The Gunlake Quarry Continuation Project (SSD-12469087)

Traffic and Transport Peer Review

For the Department of Planning and Environment

17 June 2022

APPENDIX 3: PRIMARY AND SECONDARY TRANSPORT ROUTE

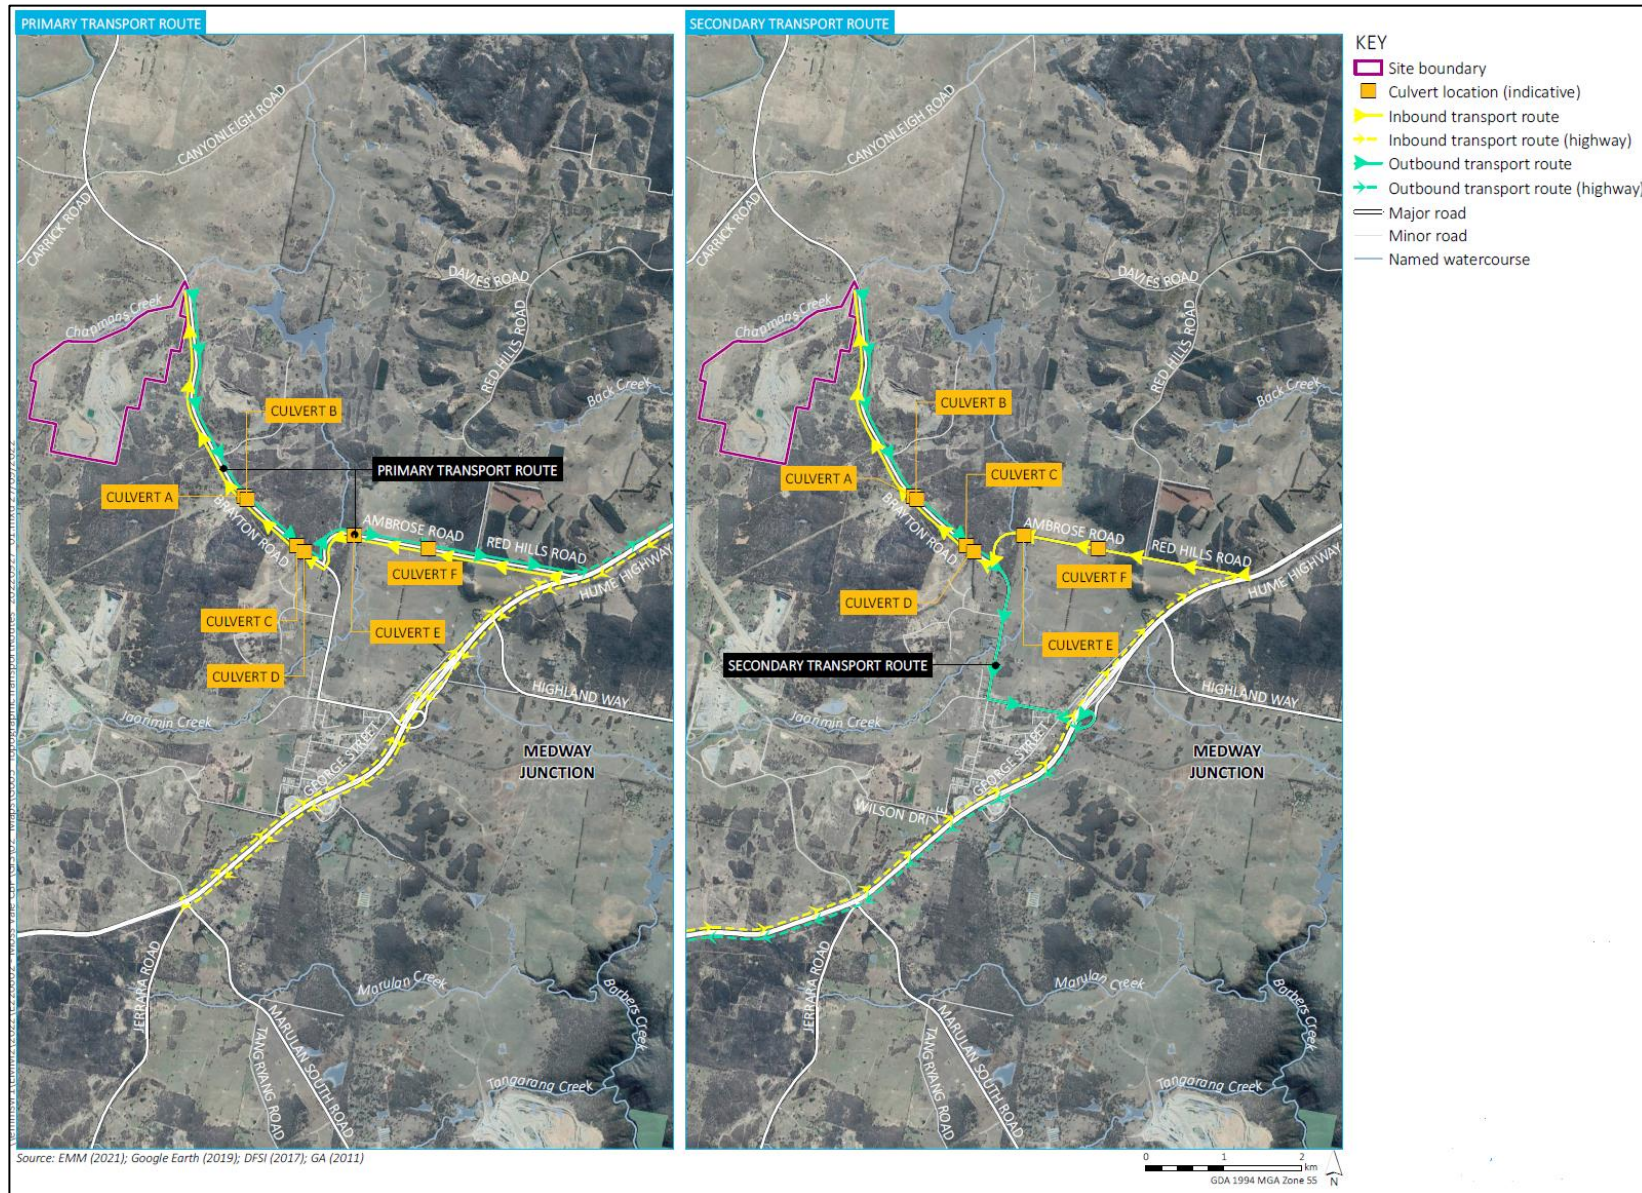
A Traffic Impact Assessment (TIA) report has been prepared by EMM Consulting in support of a further proposed expansion of quarry operations which forecasts the increase in traffic and resultant impacts. The 'Continuation Project' results in an additional 80 daily traffic movements to the Primary Transport Route compared to the Extension Project as last modified in June 2021. It is noted that the development proposal does not contribute any additional trips to the Secondary Transport Route, as described in Figure 1.1.

The SIDRA analysis indicates that the Continuation Project does not have a perceptible level of service (i.e. intersection delay) impact at the analysed intersections. However, the impact of increased heavy vehicles on travel times along the Primary and Secondary Transport Routes was not assessed as part of the TIA, however the ARRB Road Safety Assessment included a climbing lane assessment which considered the impact of reduced speeds through the vertical crest on Ambrose Road, which would have largest impact on travel times. The ARRB climbing lane assessment did not support climbing lanes based on:

Given the very low volume of non-quarry related traffic on Ambrose Road and the relatively short distance of traffic impacts by slow-moving truck, Bitzios Consulting is of the view that the impacts and cost would outweigh the benefits of constructing climbing lanes on Ambrose Road.
